RE: Howard Road Short Plat (SP-08-00048) submission fee received (\$380.00/receipt #3426)

SUBJECT: Howard Road Short Plat SP-08-48

Thank you for the opportunity to comment on the short plat of approximately 8.19 acres into 2 lots, proposed by Paul Kylo [SP-08-00048]. We have reviewed the application and have the following comments.

Thank you for the opportunity to comment on the Howard Road Short Plat, SP-08-00048. Pursuant to the Memorandum of Agreement between Kittitas County and the Washington State Department of Ecology all the future residential well connections serving the proposed lots shall be required to have meters installed. Metering results shall be recorded in a manner consistent with Kittitas County and Washington State Department of Ecology requirements.

**HOWARD ROAD SHORT PLAT
 PART OF SECTION 31, T. 19 N., R. 18 E., W.M.
 KITTITAS COUNTY, WASHINGTON**

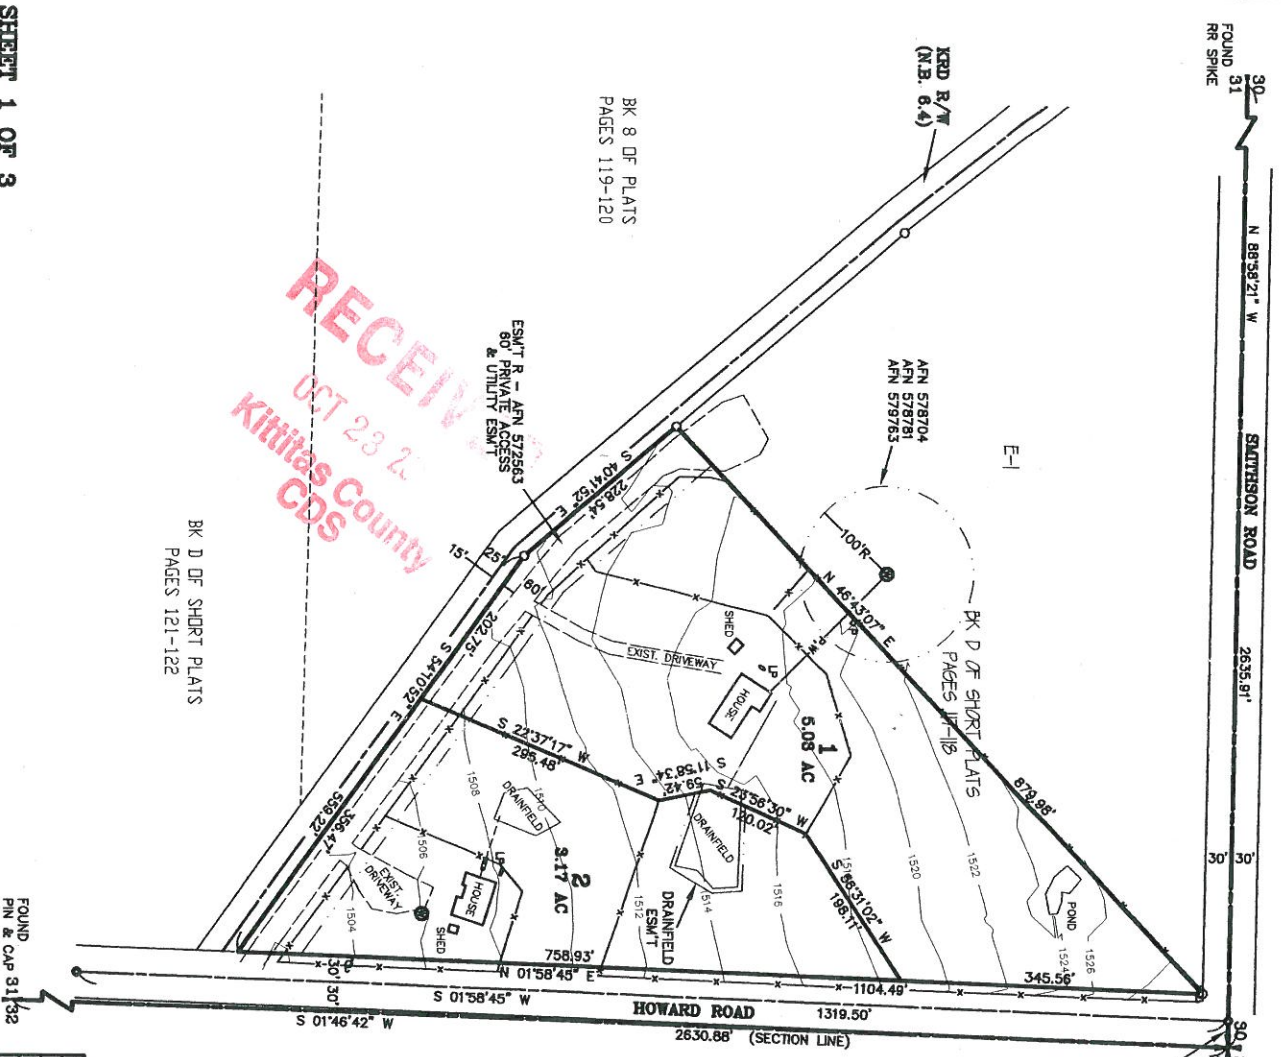
2. Private Road Improvements: Access from Howard Road to the cul-de-sac shall be constructed to meet or exceed the conditions of a Low-Density Private Road. A cul-de-sac shall be constructed after the driveway to Lot 2. See Kittitas County Road Standards, 9/6/05 edition.

3. Cul-de-Sac: A cul-de-sac turn-around having an outside right-of-way or easement diameter of at least 110 feet shall be constructed at the closed end of all dead-end roads serving 3 or more lots. The driving surface shall be at least 96 feet in diameter. Cul-de-sacs must also conform to the requirements specified by the 2006 International Fire Code. Contact the Fire Marshal regarding any additional cul-de-sac requirements.

The potable water plat note is incorrect (plat note #8). Please replace the plat note with the following:

Please also include the following plat note:

"The approval of this division of land includes no guarantee that there is a legal right to withdraw groundwater within the land division. The approval of this division of land provides no guarantee that use of water under the ground water exemption (RCW 90.44.050) for this plat or any portion thereof will not be subject to curtailment by the Department of Ecology or a court of law. "

"Metering will be required on all residential well connections and metering results shall be recorded in a manner consistent with Kittitas County and Washington State Department of Ecology requirements."
